**Port Kembla Gas Terminal – EPA Comments on Environmental Impact Statement**

I am writing in response to the Department of Planning and Environment (DPE) request of 13 November 2018 to provide advice on the exhibited Port Kembla Gas Terminal development application (DA) (CSSI 18\_9471). The proposal, if approved, will require Environment Protection Licences issued by the Environment Protection Authority (EPA) for both the construction and operational phases of the project.

Attachment 1: EPA submission on Port Kembla Gas Terminal

APPENDIX

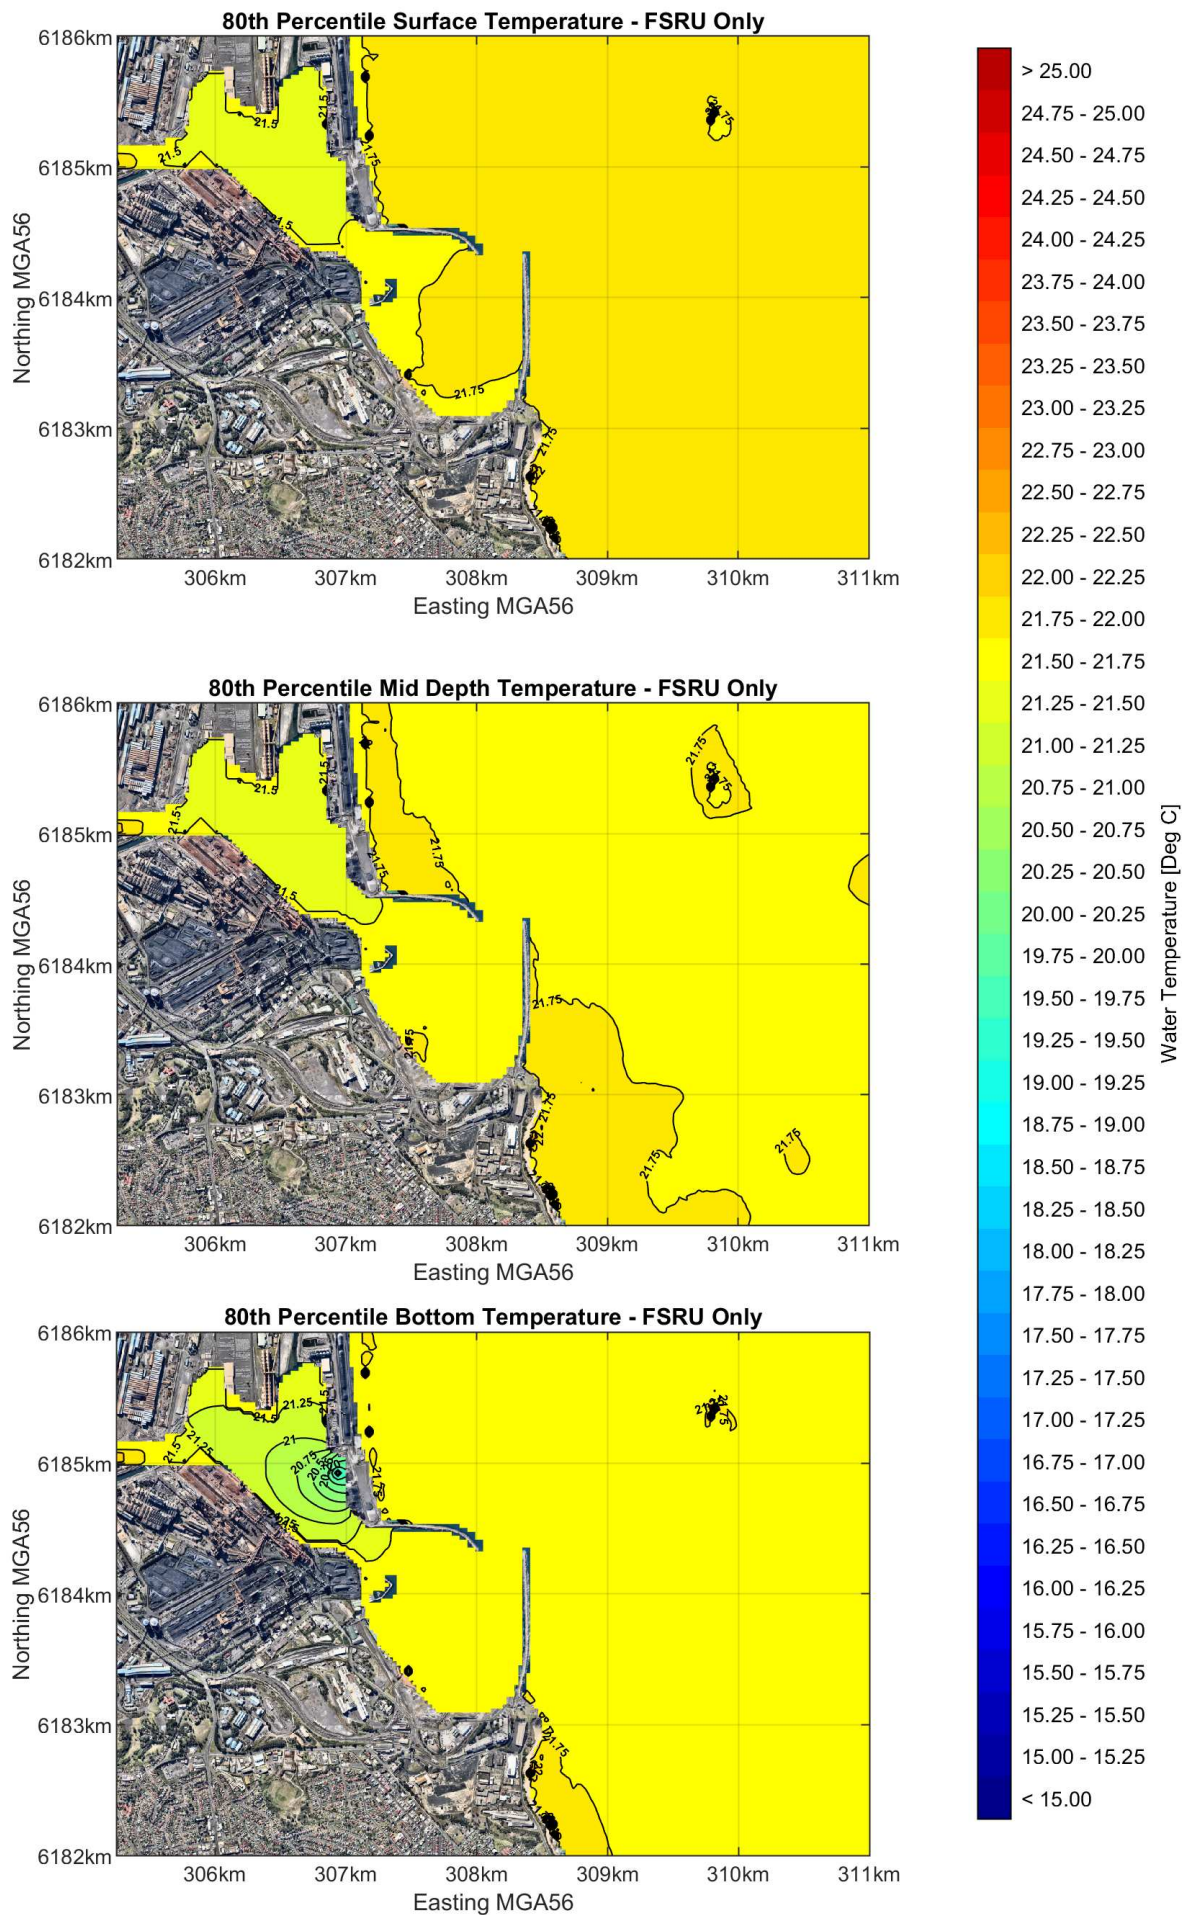
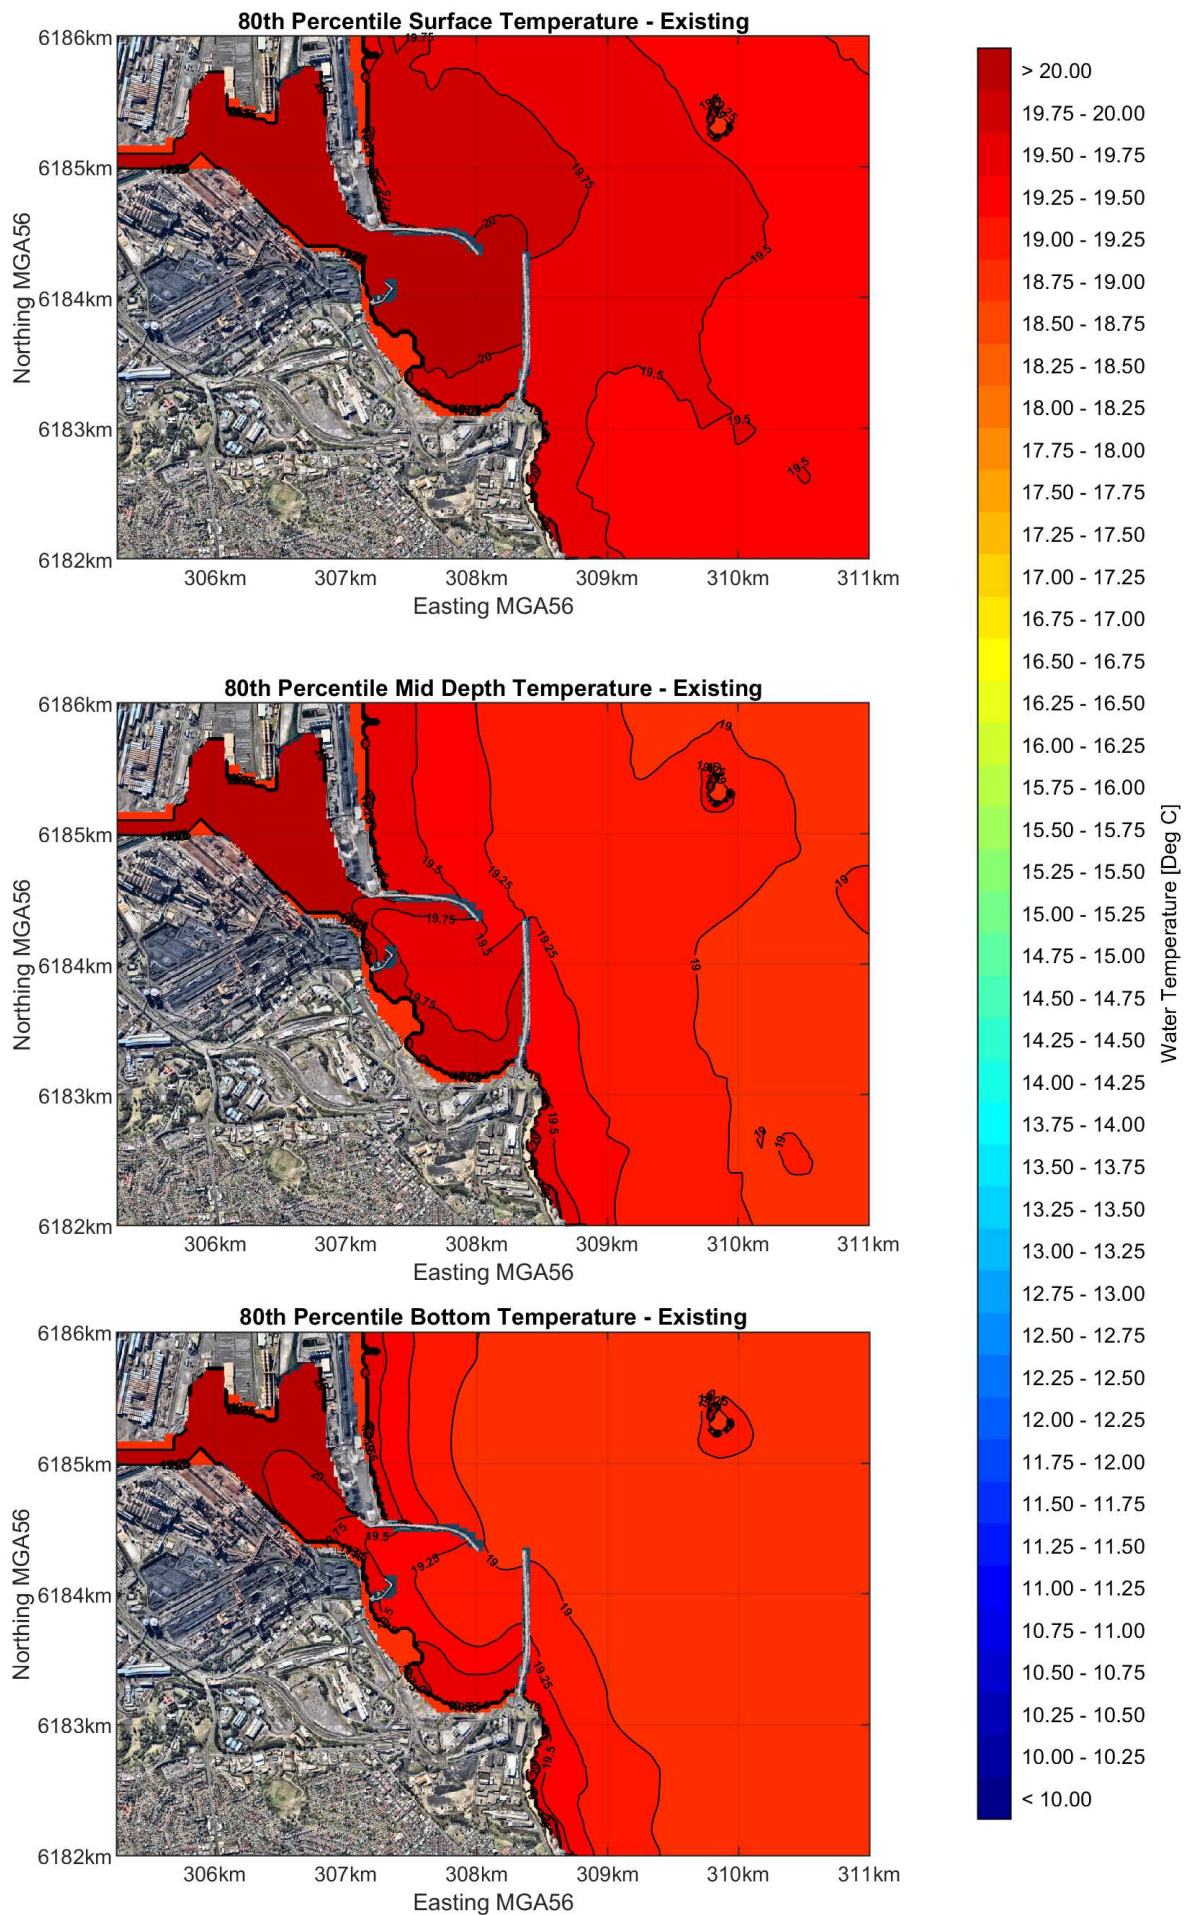
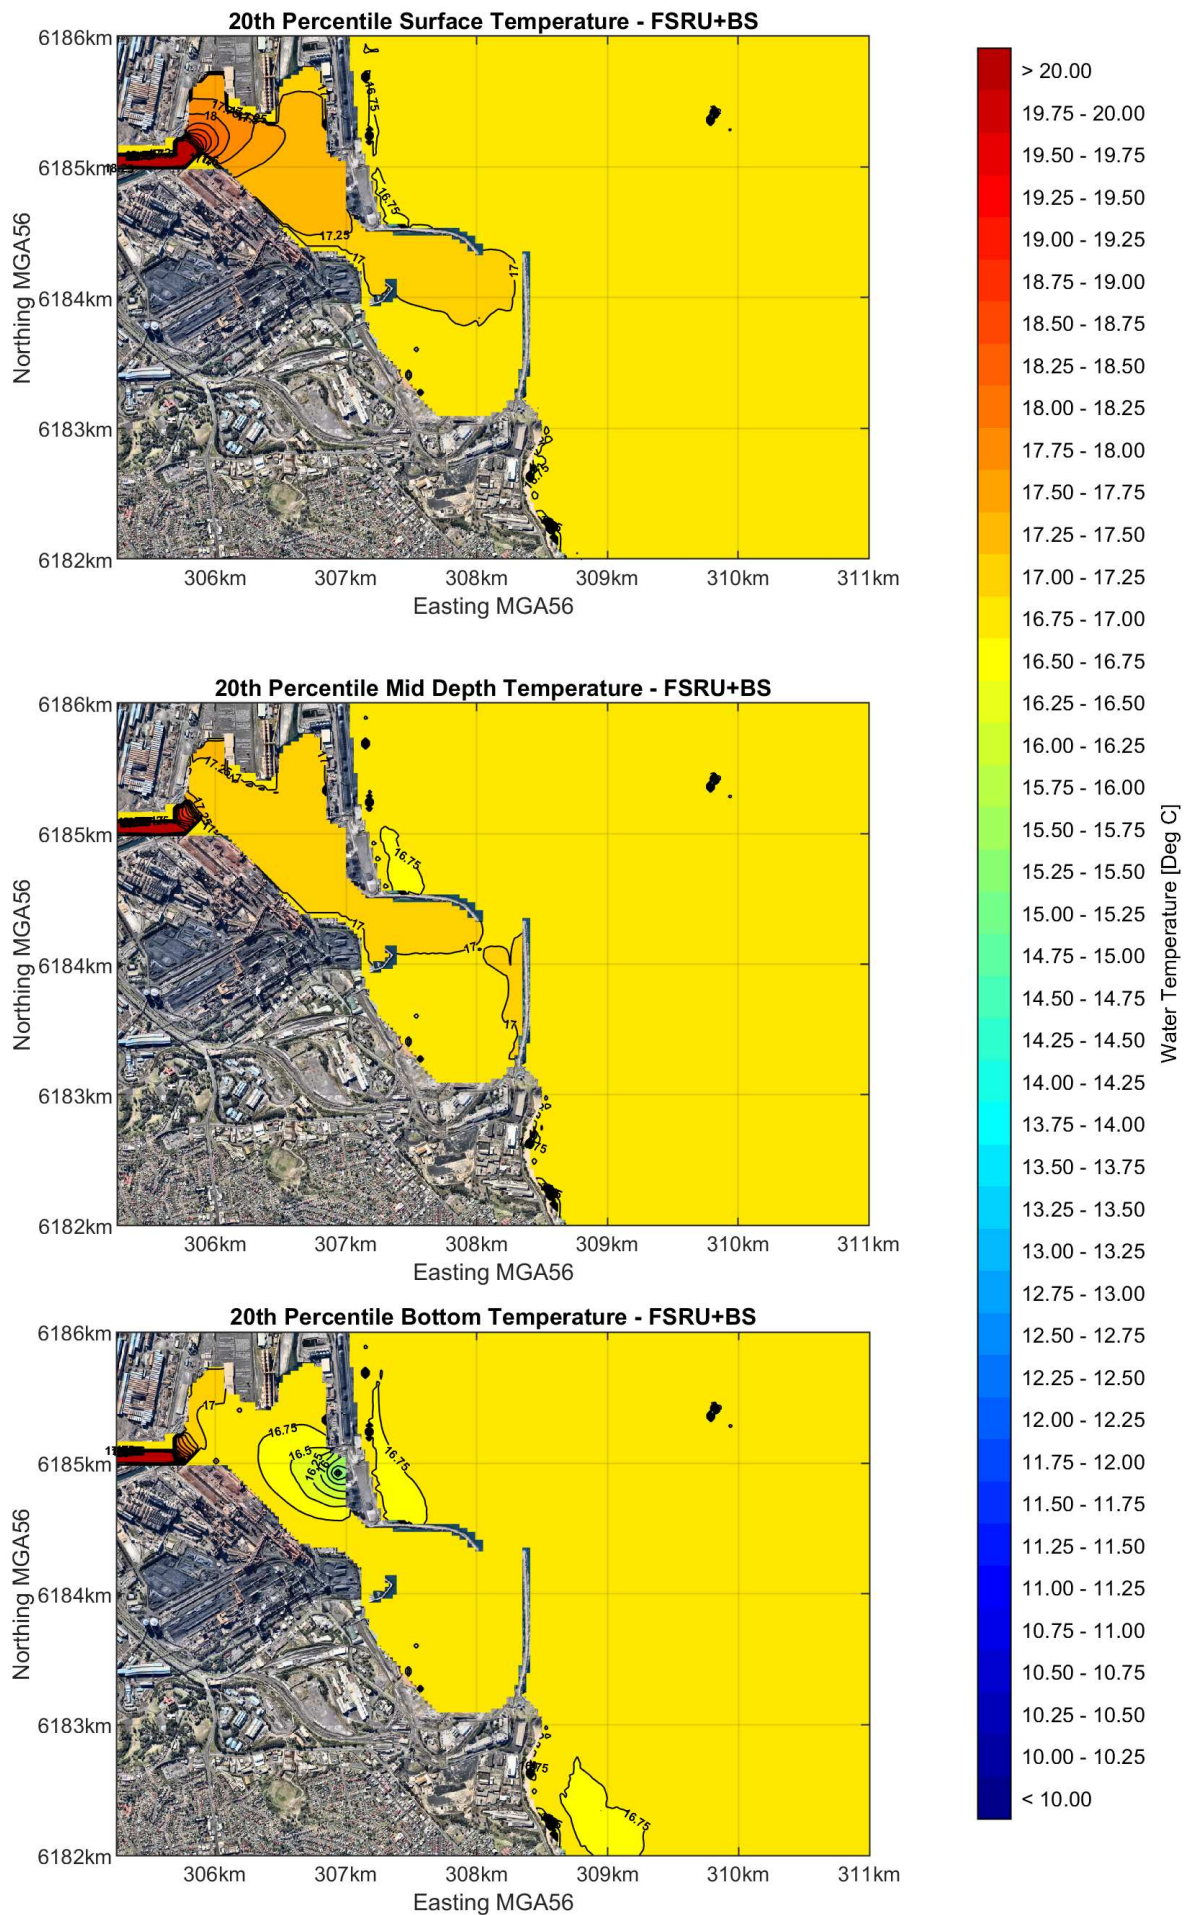
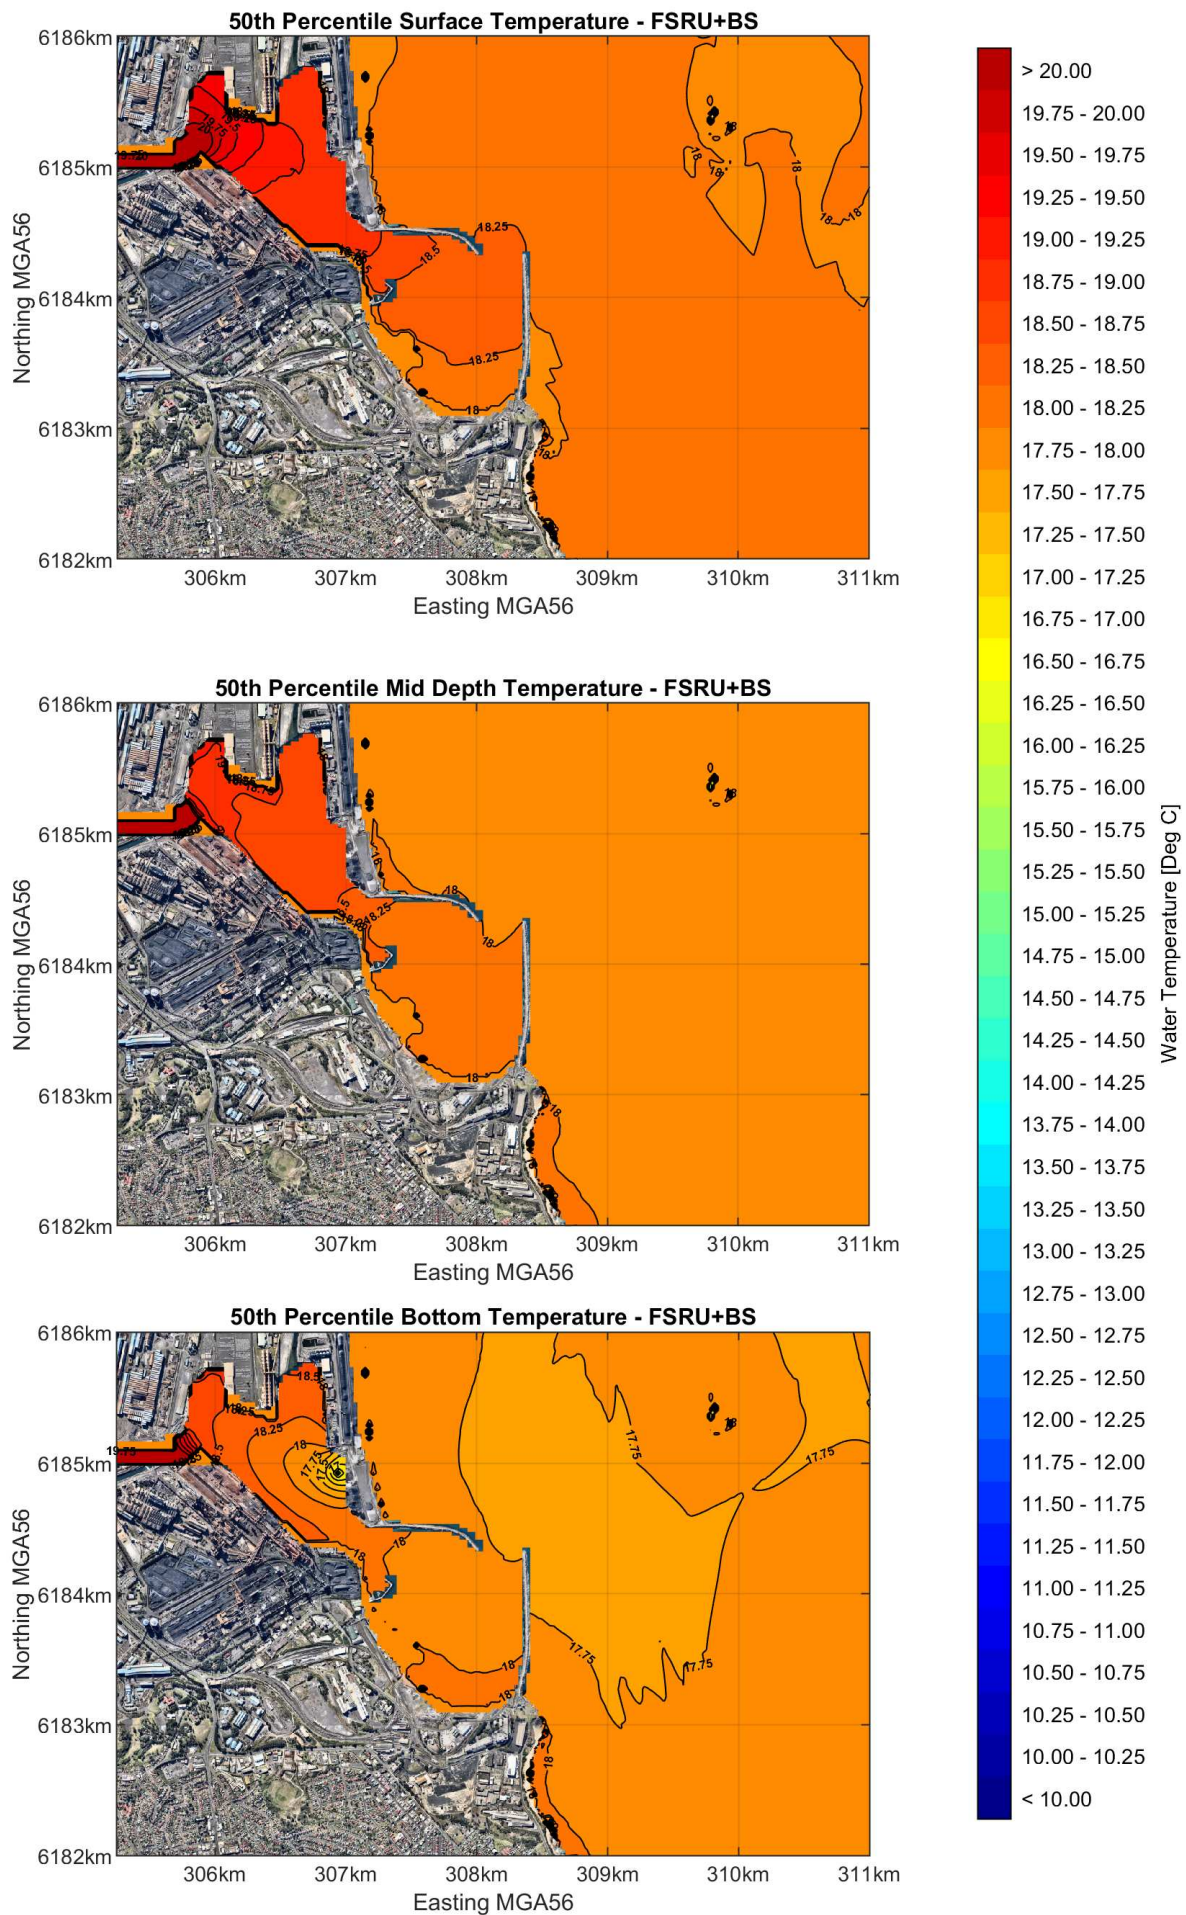
The EIS does not appear to have adequately described the impact over each season or in accordance with water quality trigger values in the Australian Water Quality Guidelines. The assessment should consider if the water quality criteria is achieved at the edge of the near-field mixing zone. The water quality guidelines for temperature decreases states, *for cold water discharges, the median temperature should not be permitted to fall below the 20%ile temperature value obtained from the seasonal distribution of temperature data from the reference ecosystem (page 8.2–67 ANZECC 2000, Vol 2).*

The resolution in the *Thermal Plume Modelling* charts (Appendix F) provided is limited and the associated temperature scale should capture the minimum modelled temperature, and not just, *less than 16.5 degrees Celsius*.

- details on the full range of modelled water temperatures.
- where potential impacts do not meet WQOs at the edge of the near field mixing zone, further practical mitigation measures that can be taken to mitigate the impacts of the pollution must be assessed, including but not limited to:
